1no. new dwelling (re-submission of approved application reference EP/105/16/PL).
Seahaven (Land West of Ash Hollow) Seafield Road East Preston

Thank you for your internet representation made on 2nd August 2019 which has been recorded as '**an objection**' with the comments as follows:

I am commenting on this application on behalf of the East Preston and Kingston Preservation Society.

Job Title	Seahaven, Seafeld Road, East Preston		
Client	Mr & Mrs D Guise		
Drawing Name	Elevations		
Drawing Status	Planning		
Drawn by	DF	Date	June 19
Checked by		Date	
Drawing Scale	1:100 at A1		
Drawing No	Status	Revision	
193008/	03

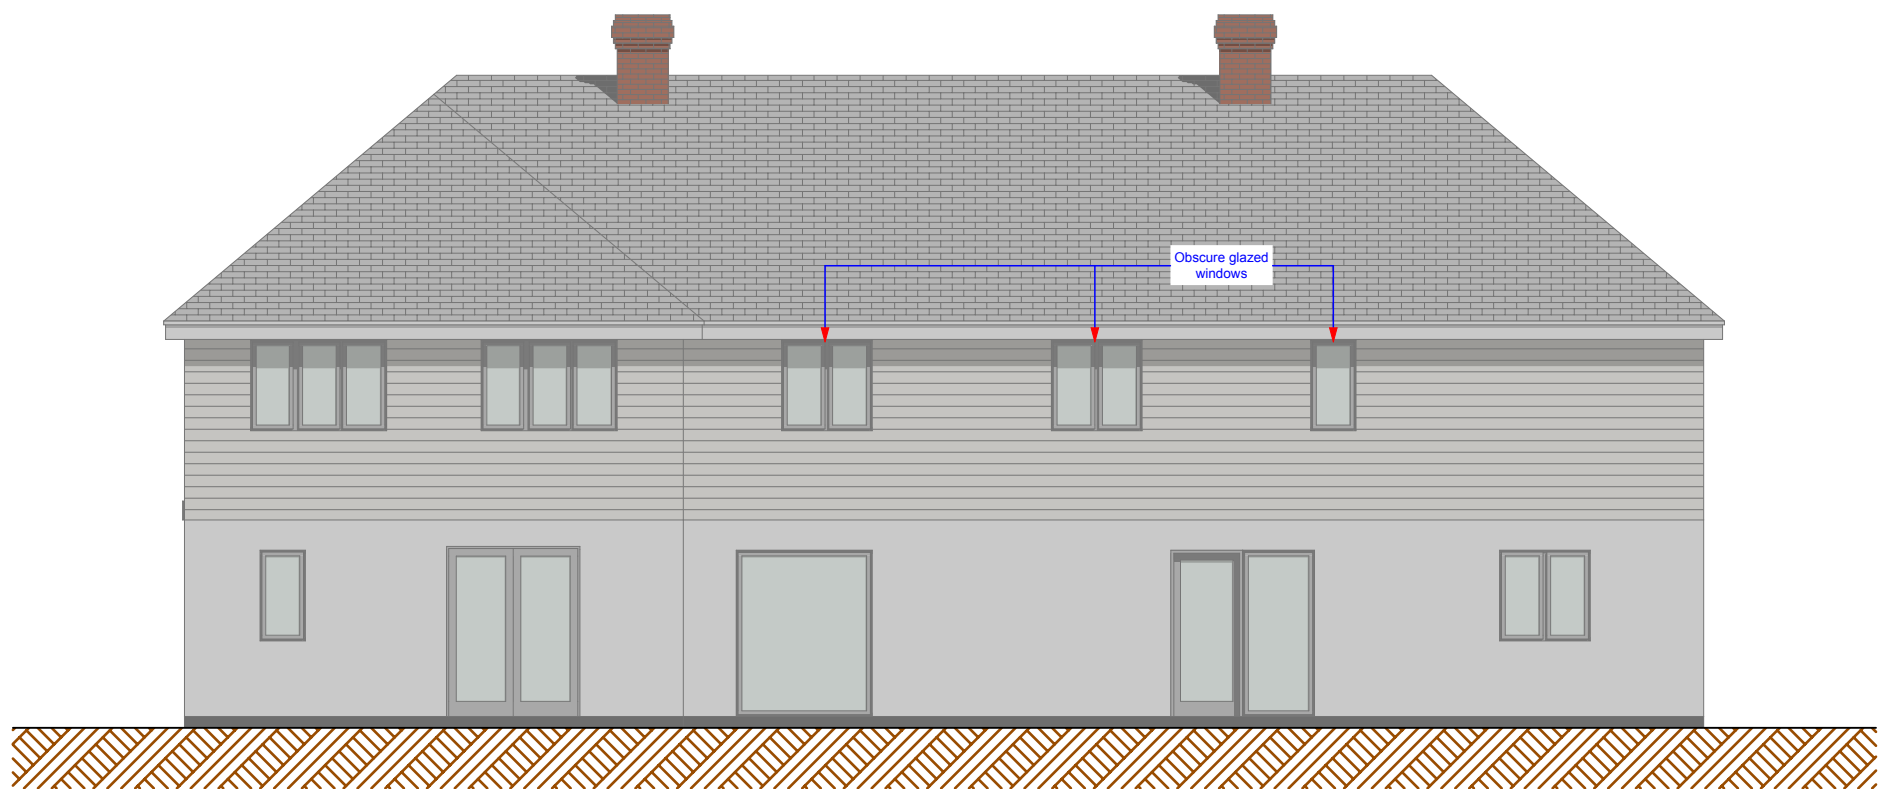
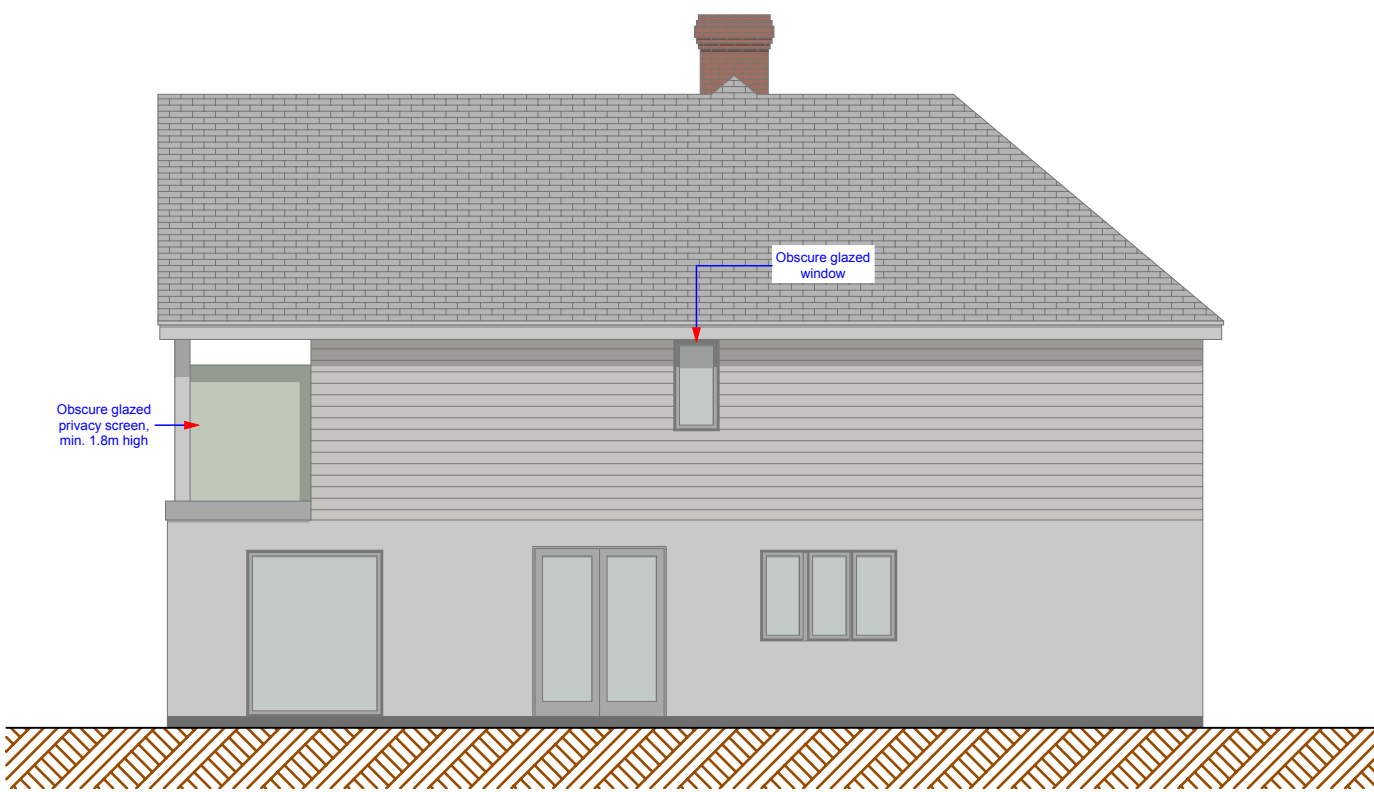
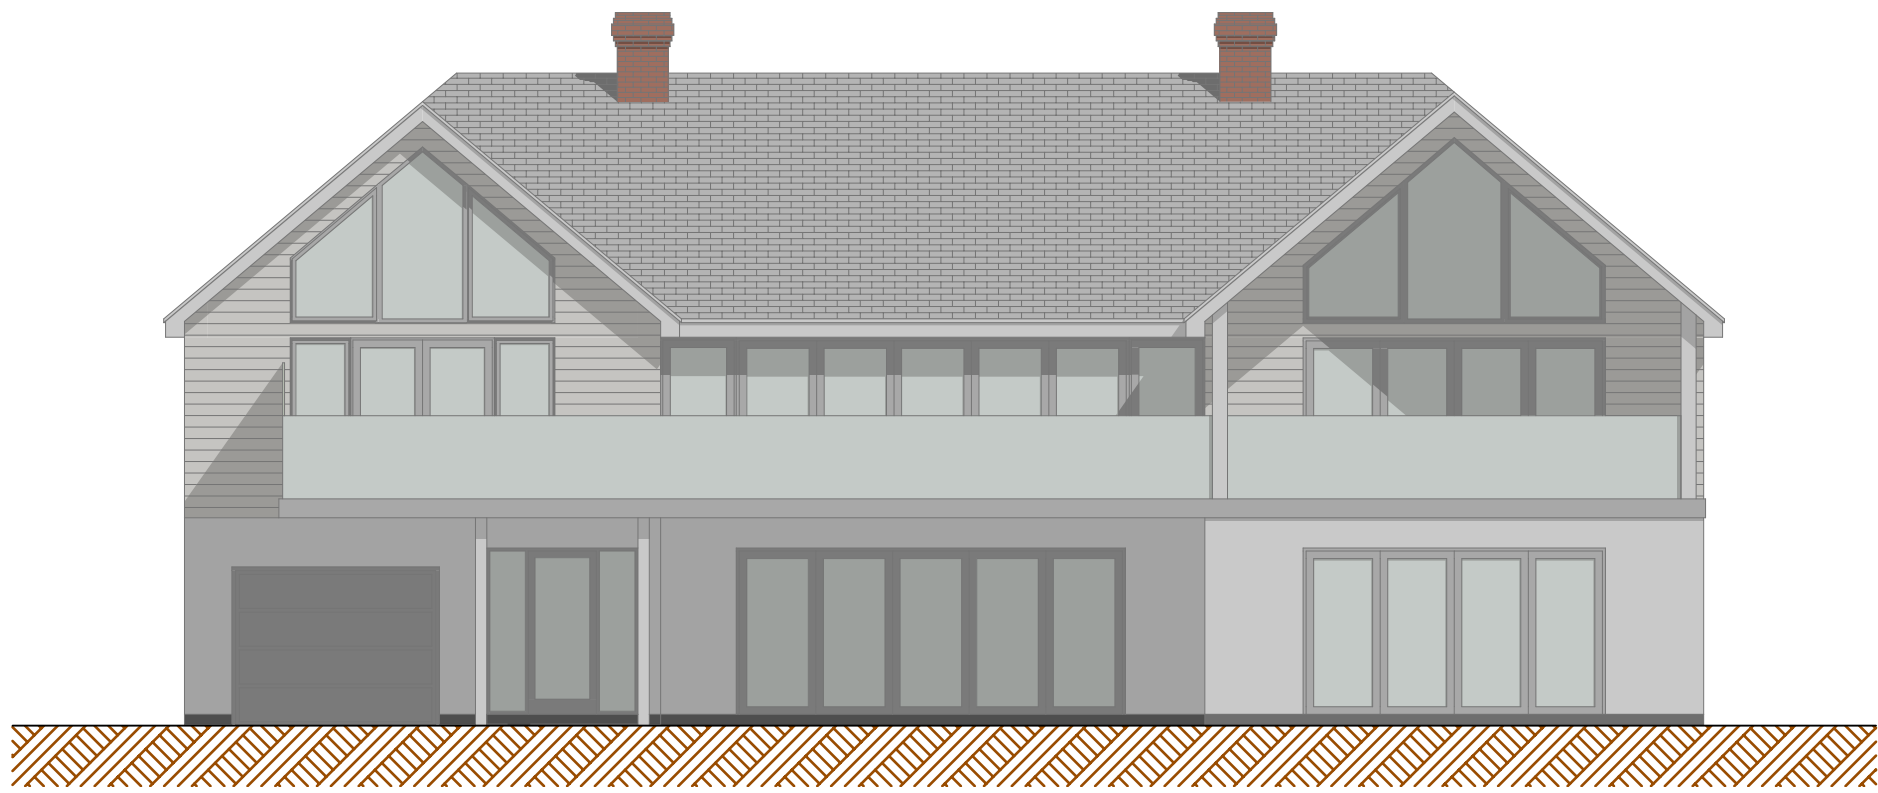
The present application shows a house that is larger and taller than the design for which planning permission has been granted, and which would be built of different materials. Seafield Road is in an Area of Character, and development should therefore preserve, and where possible enhance the special character of the area. In Seafield Road, this character is an attractive streetscape with mature hedges and houses set back from the road, built to a very low density, which creates a sense of space.

The front boundary treatment of this proposed house should therefore be a hedge, supplemented by trees. The size and height of the house, on a plot smaller than others in the road, would jeopardise the present sense of space. These features would also produce a house that contravened Policy 2 of the East Preston Neighbourhood Plan, which states that large houses on small plots should be avoided; and Policy D DM1 (1) of the Arun Local Plan because the house would not reflect the character of the surrounding area. It would be too urban in character for its surroundings, and would appear too large and tall for its plot.

The proposed materials would also contravene Policy D DM1 of the Local Plan and Policy 1 of the Neighbourhood Plan. The use of fibre cement weatherboarding on the first floor walls and a slate roof, would not reflect the character of the materials used in the surrounding area.
